Address: The Hawthorns Dewsbury Road, Upper Edge, Elland HX5 9JU

Application number: 2024/90602	
What is the application for?:	Discharge conditions 3 (boundary fencing), 5 (cycle storage), 7 (Arboricultural)
Address of the site or building:	Bryan Wood Residential Home, 1, Bryan Road, Edgerton, Huddersfield, HD2 2AL
Postcode:	B60 4AD

project: Bryan Wood
Huddersfield
client: Polaris Children's Services
drawing: Boundary treatment +
fences
drawing number: **23-025-15**
revision: A (06-06-24)
date: May 24
scale: 1:500
original size: A3
issue: Approval
drawn: DUJ
checked:

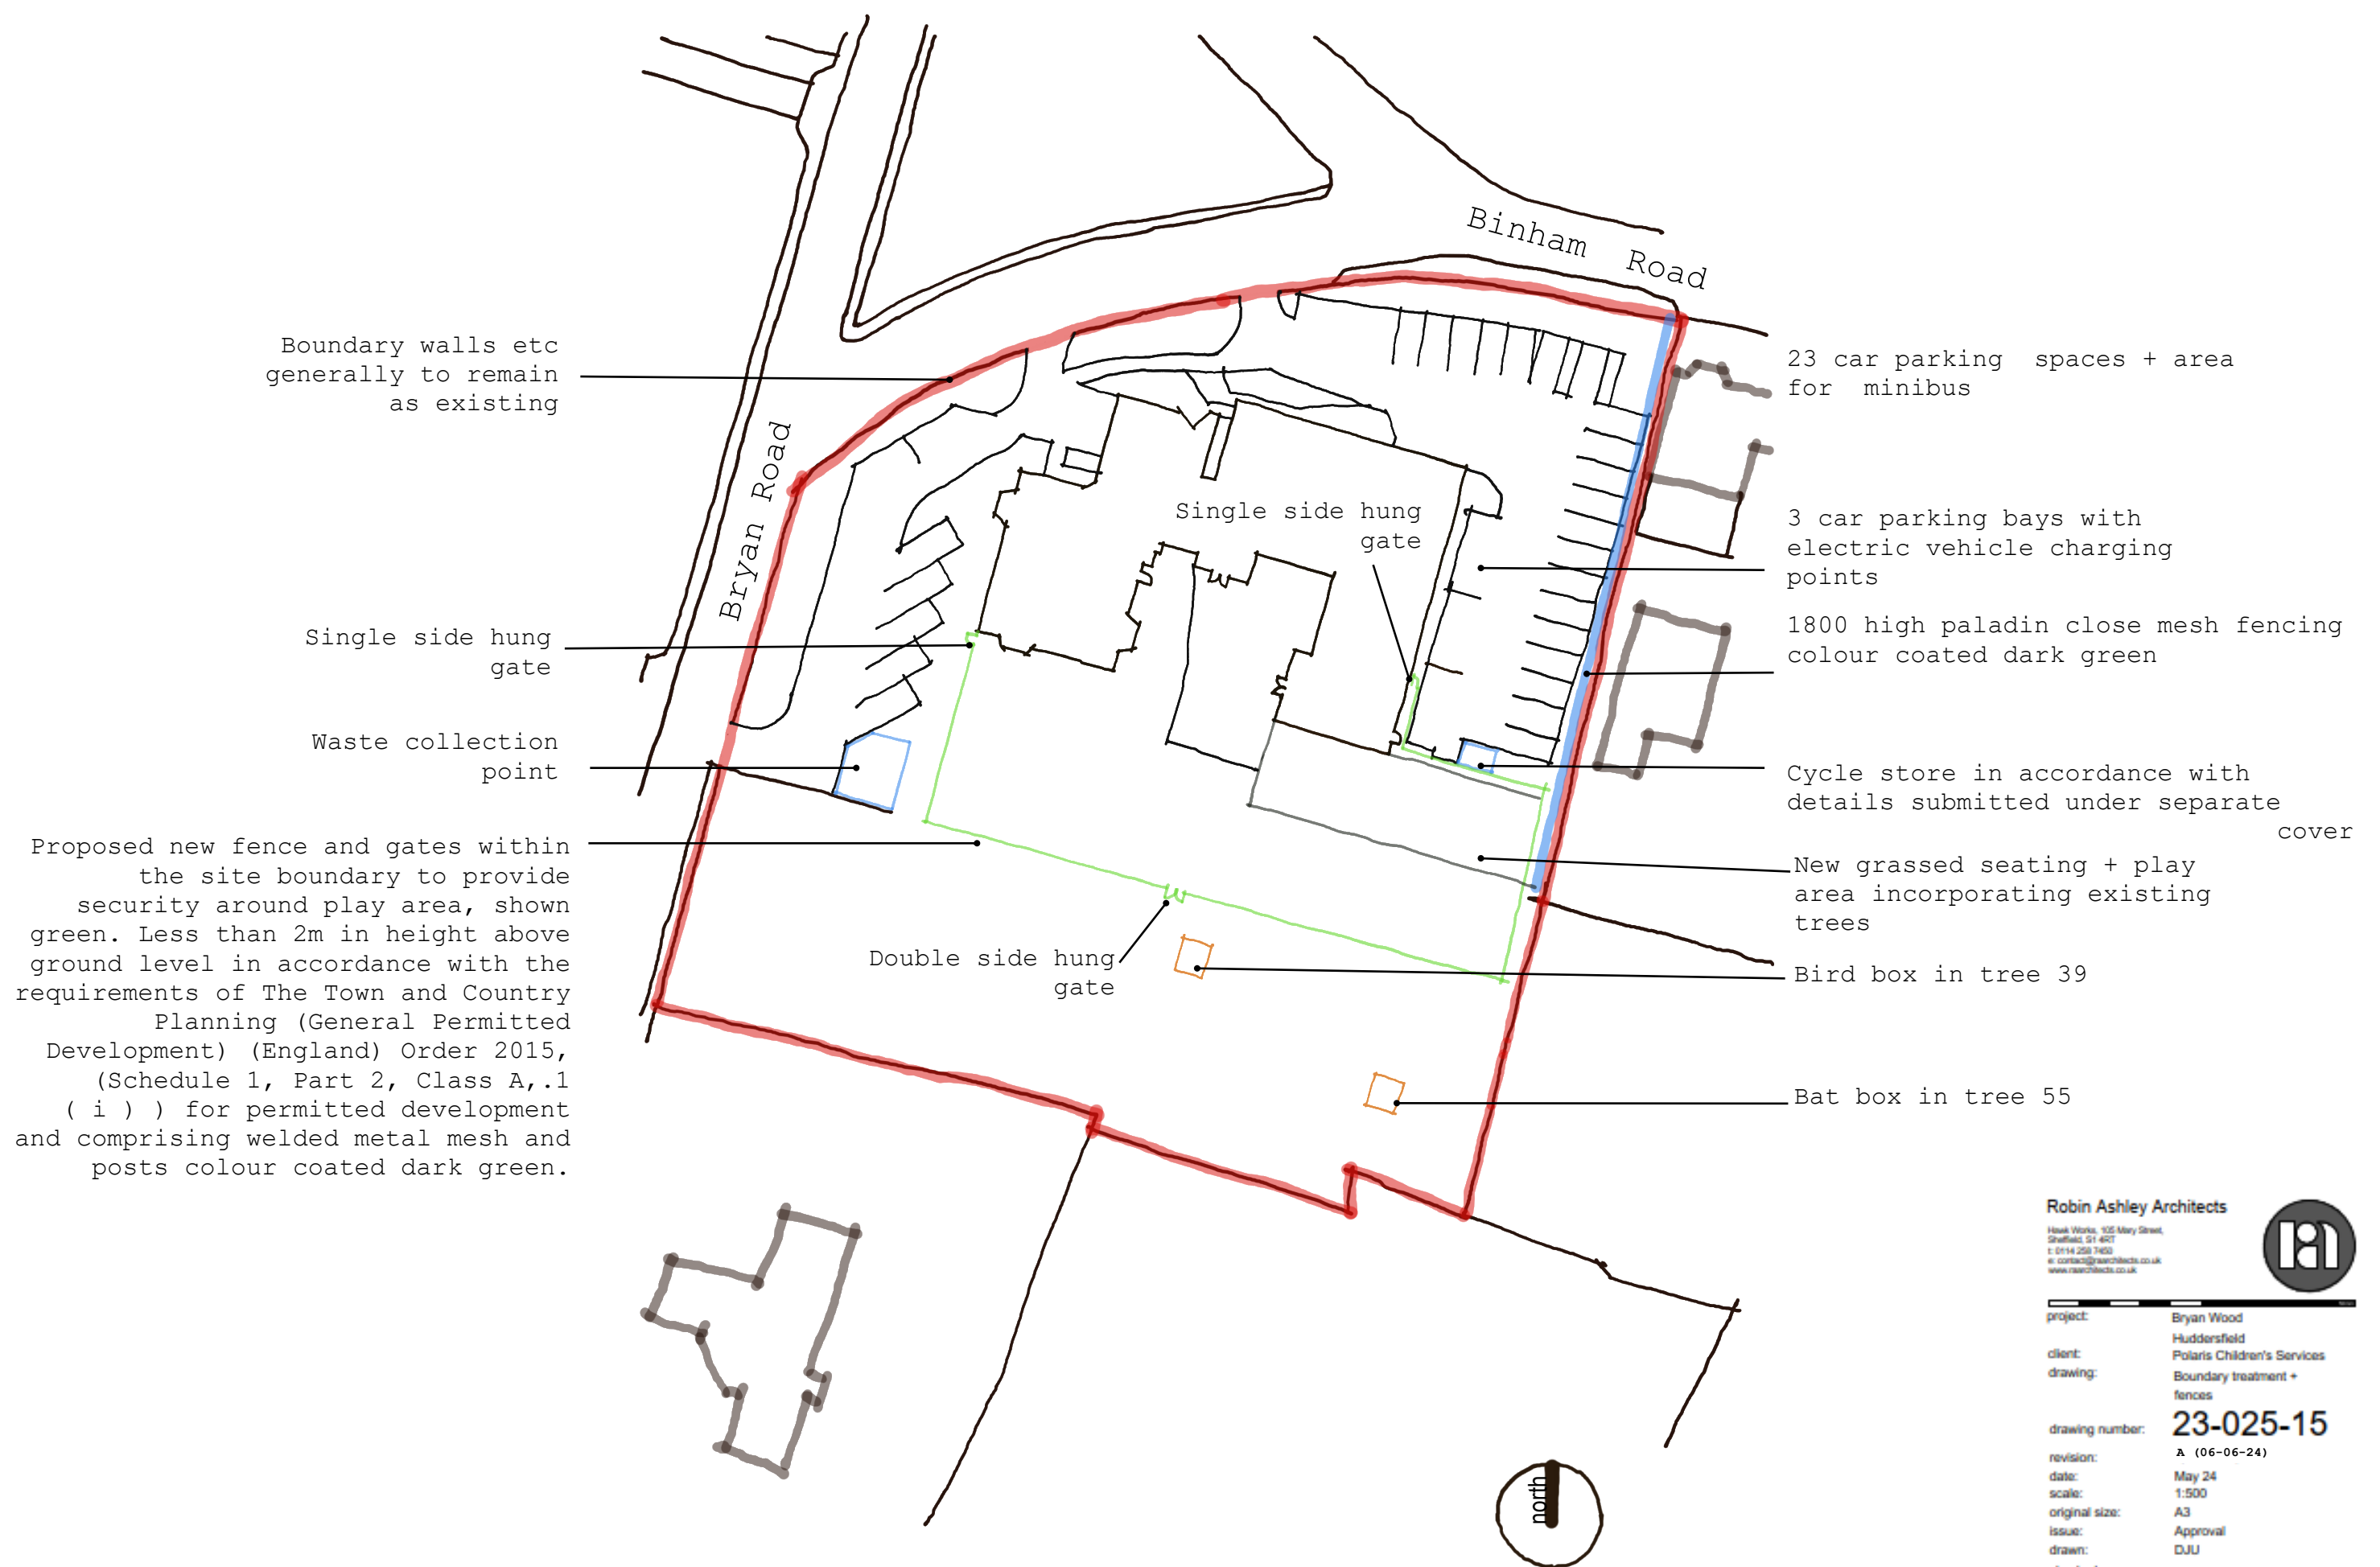
Type of comment: An objection	
Do you wish your comments to be published on the website anonymously?	No
<p>I am the owner of The Lodge, 8 Binham Road, Edgerton, HD2 2AP . A planning application has been submitted showing a proposed 1.8 M high timber boundary fence on our shared boundary between the former Brian Wood Care Home and my property. The basic plan shows the new fence extending to the northern most point of the boundary which will cut natural light from the north facing room of my property Number 8. Furthermore there is no need to fence to the most Northerly point as there is already a Stone pillar, stone boundary wall with wall topped railings already in situ at the North West corner of my property boundary. When landscaping my property I went to a lot of effort to be sympathetic to Edgerton Conservation Area Ethos using traditional materials and adopting appropriate architectural styles, this timber fence would appear obstructive to the openness of the area if extending to the northern most boundary. I have also concerns regarding additional water run off when removing the existing grassed area to a tarmac hard surface in the formation of the additional parking spaces, as the natural fall of the land is in the direction of my property. I hope therefore that a porous material is specified to avoid any excess water issues.</p> <p>For the record I was unaware of this original planning application effecting Bryan Wood Care Home as my tenant at the time did not pass on any planning notice posted by Kirklees Planning.</p>
